## Attachment 2: OEH Review of Impacts of Springvale Mine Extension Project (SSD 5594) on Upland Swamps

### Impacts on Newnes Plateau Shrub Swamps

Figure 26 Plan of Japan (Trail 6) Shrub Swamp

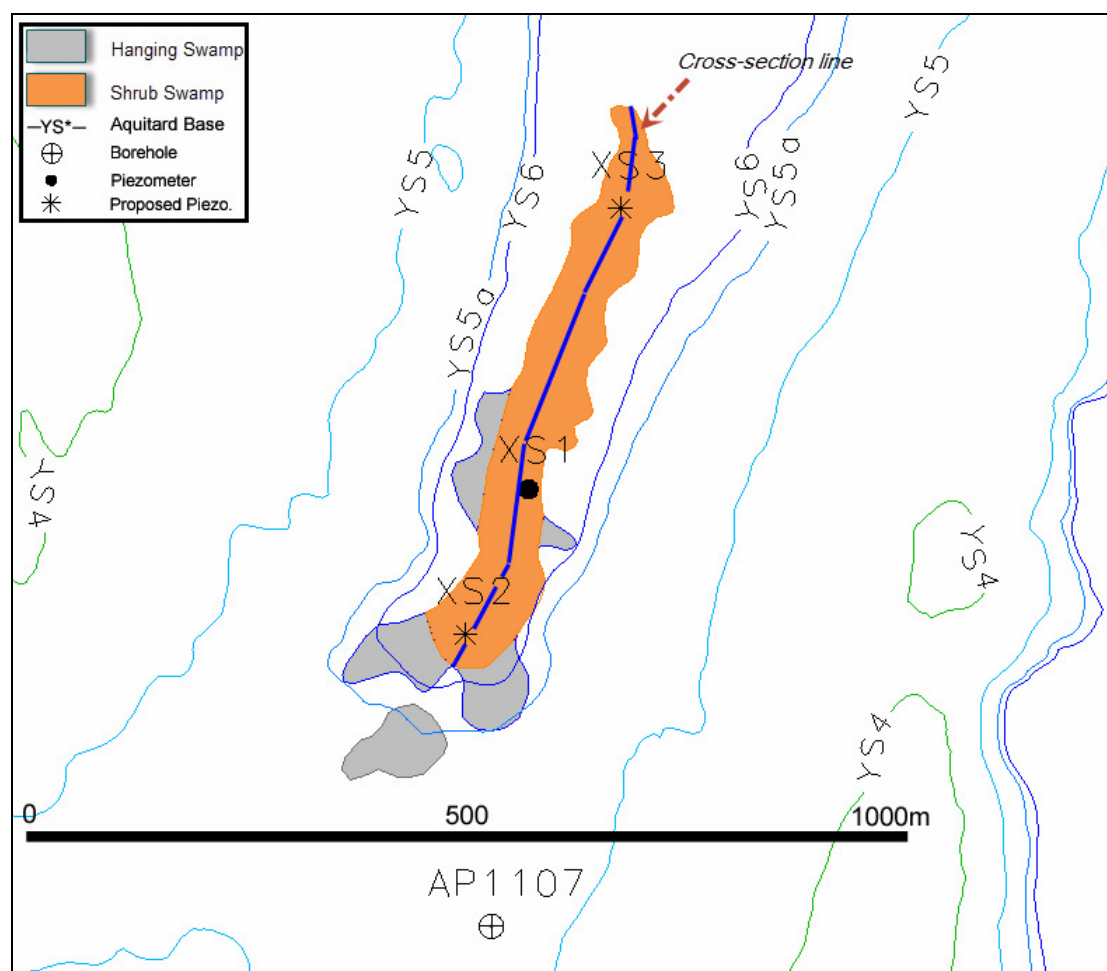
Mining is proposed directly underneath (or in the vicinity of) ten of the largest NPSS (Sunnyside East, Carne West, Gang Gang West, Gang Gang East, Marrangaroo, Pine Swamp, Paddys Swamp, Tri-star, Twin Gully, Trail 6 Swamp) on the Newnes Plateau. Collectively these swamps make up approximately 12-15% of the known NPSS EEC.

Despite assertions that sub-critical panels will avoid or mitigate risk, the proponent's subsidence consultants identify an expectation that fracturing would occur in the top most bedrock beneath these swamps. The presence of lineament zones directly underneath many of these swamps increases the risk and severity of subsidence impacts in their vicinity. This view is supported by the IESC comments.
